Subject: RE: AB/120/20/PL and AB/ 121/20/L Old Bank House, 1 High Street, Arundel

Subject: AB/120/20/PL and AB/ 121/20/L Old Bank House, 1 High Street, Arundel

BLOCK PLAN
(1:500)

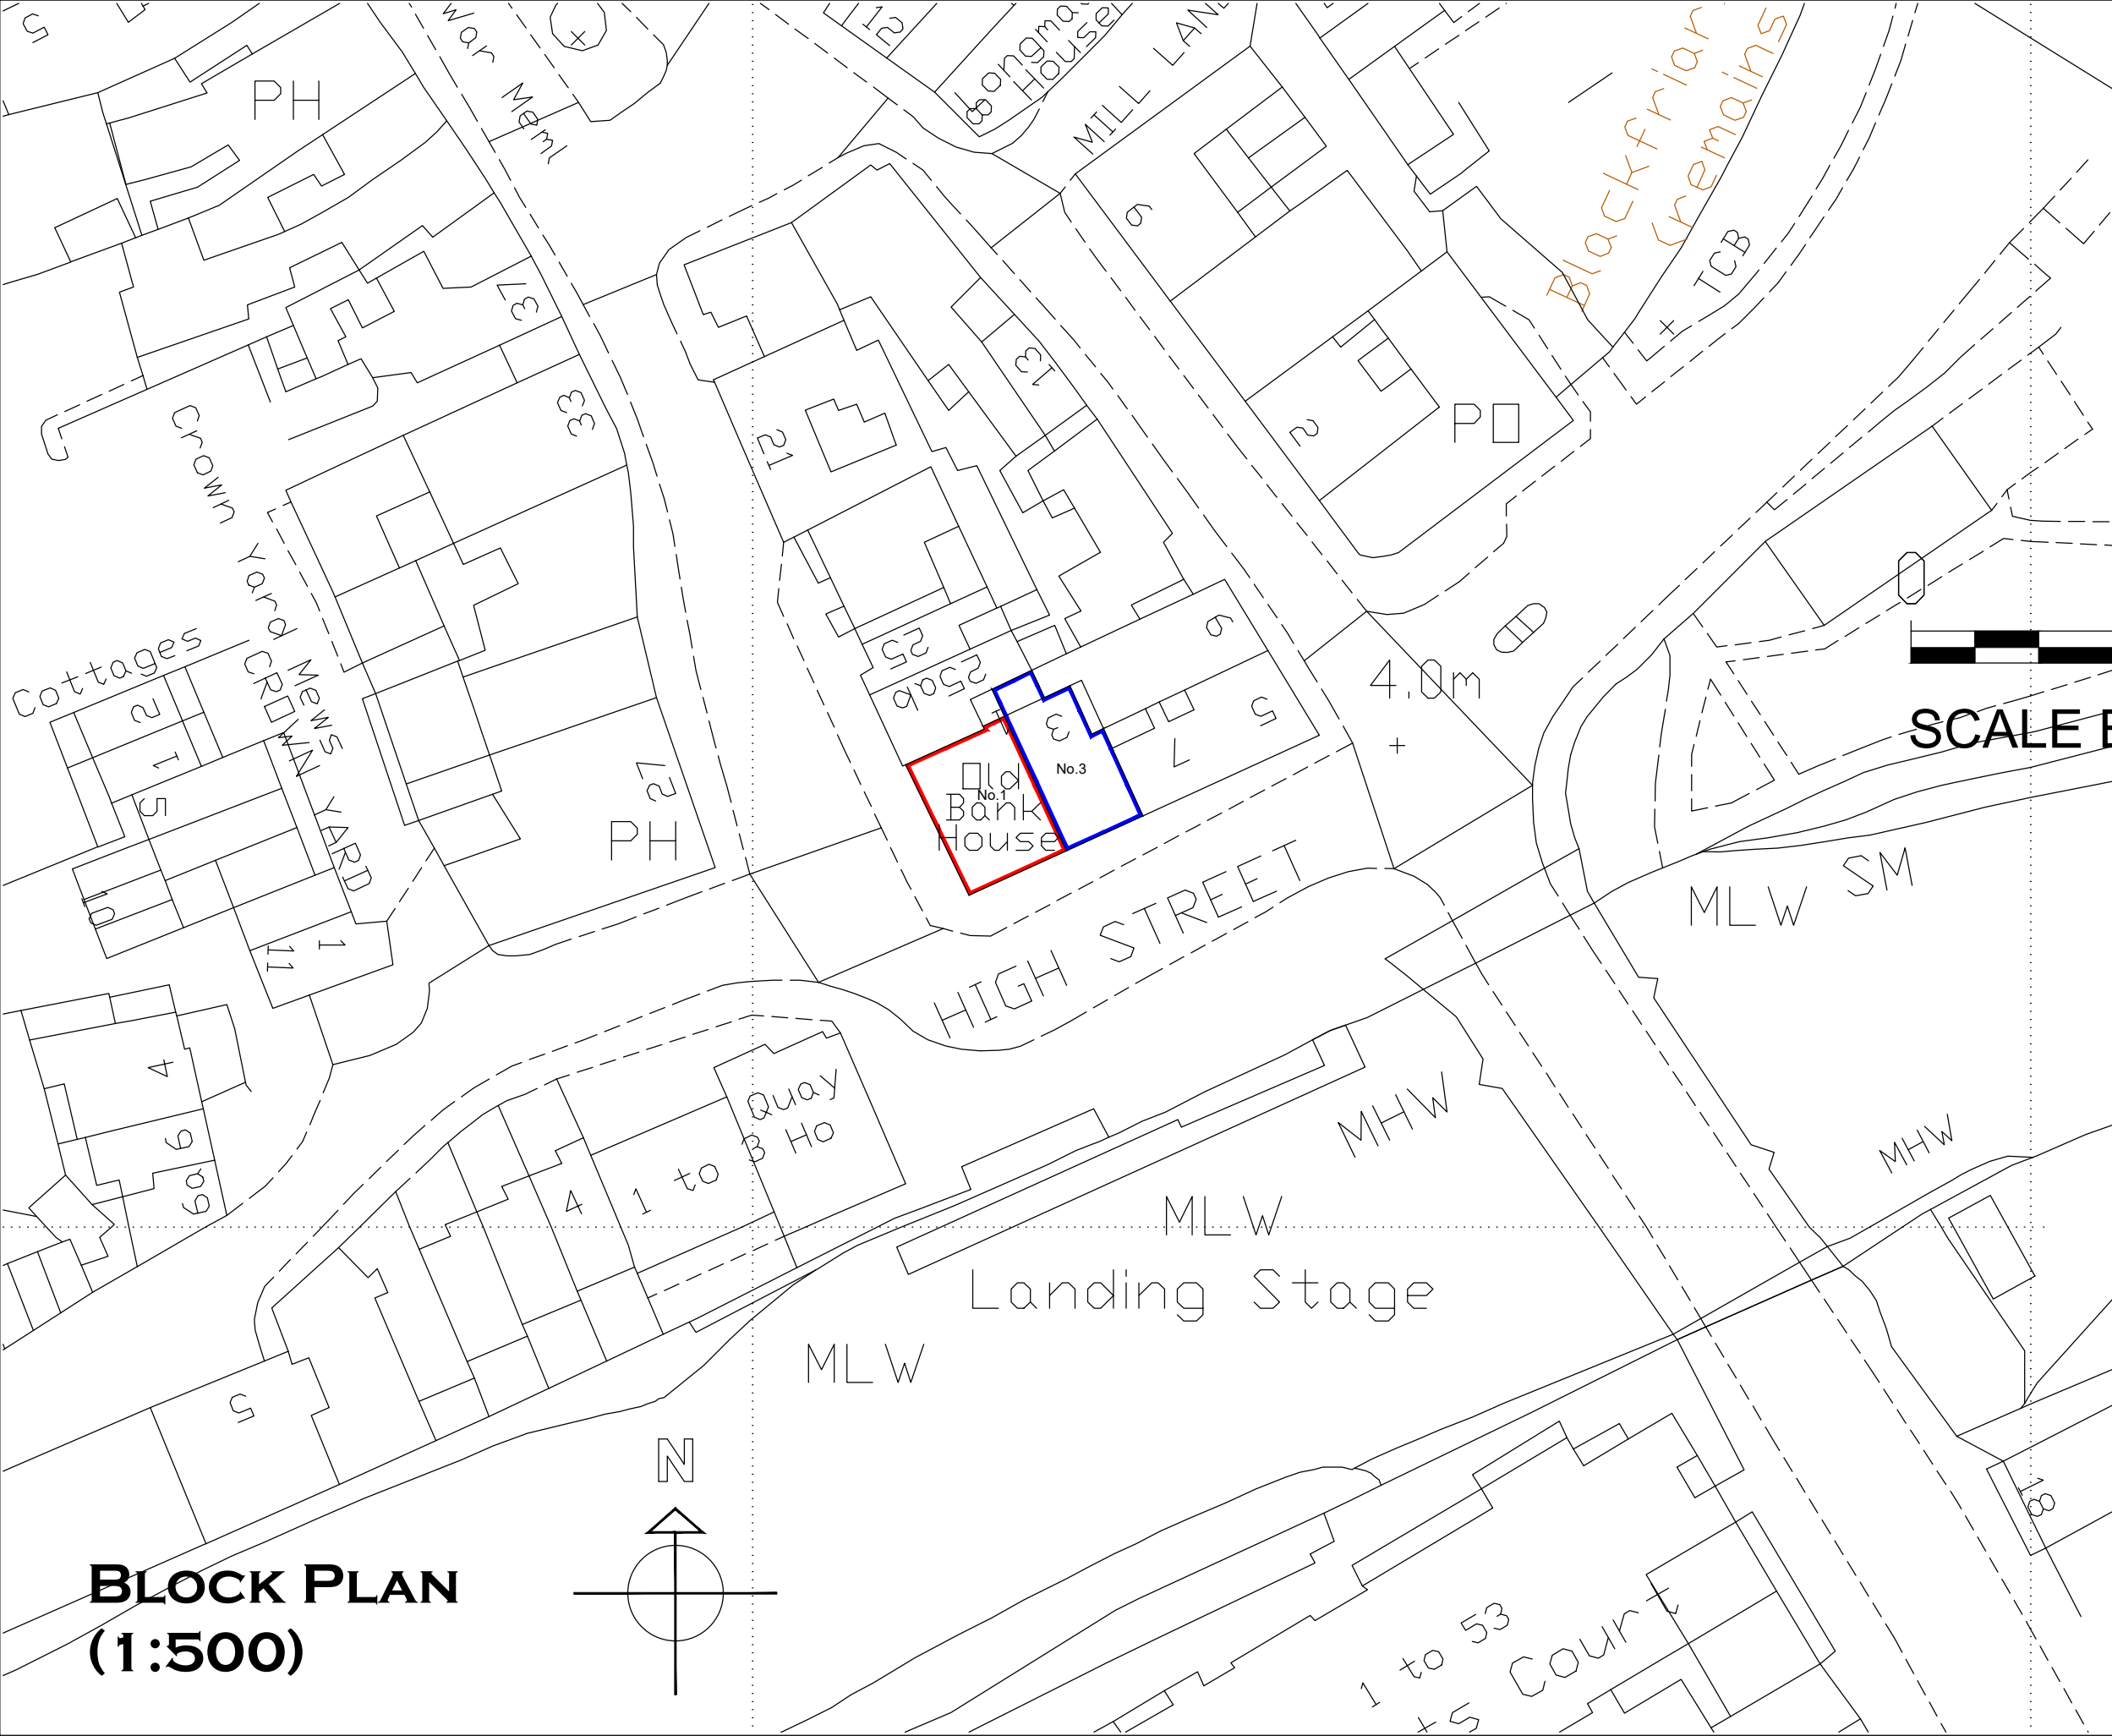
If you are happy to agree to an EOT until 29-01-2020 that will allow sufficient time for receipt of revised plans and report writing and processing and I am happy to await receipt until the new year. If the red edge of the application site is amended this may require re-advertising and a further extension of time.

I have been looking at your applications with a view to writing my reports prior to the Christmas break, but I don't think it is going to be possible given the discrepancies in the location/block and floor plans. There is no plan clearly denoting the extent of the rear outside amenity area and the red edge of the application site to the rear of the premises does not appear to tally with the ground floor plan. The shape and projection to the rear do not appear to correlate. Please can you clarify and let me have revised as soon as possible.

Thanks for the email. I will look in to this and sort out a plan to show the outside area and check the boundaries on the site plans etc and amend as required. I probably won't be able to do this until the new year as I have finished for Christmas now. I might be able to look at over the Christmas break but can we agree to leave it until the new year and I will get drawings across to you. Happy to agree extension of time if required.
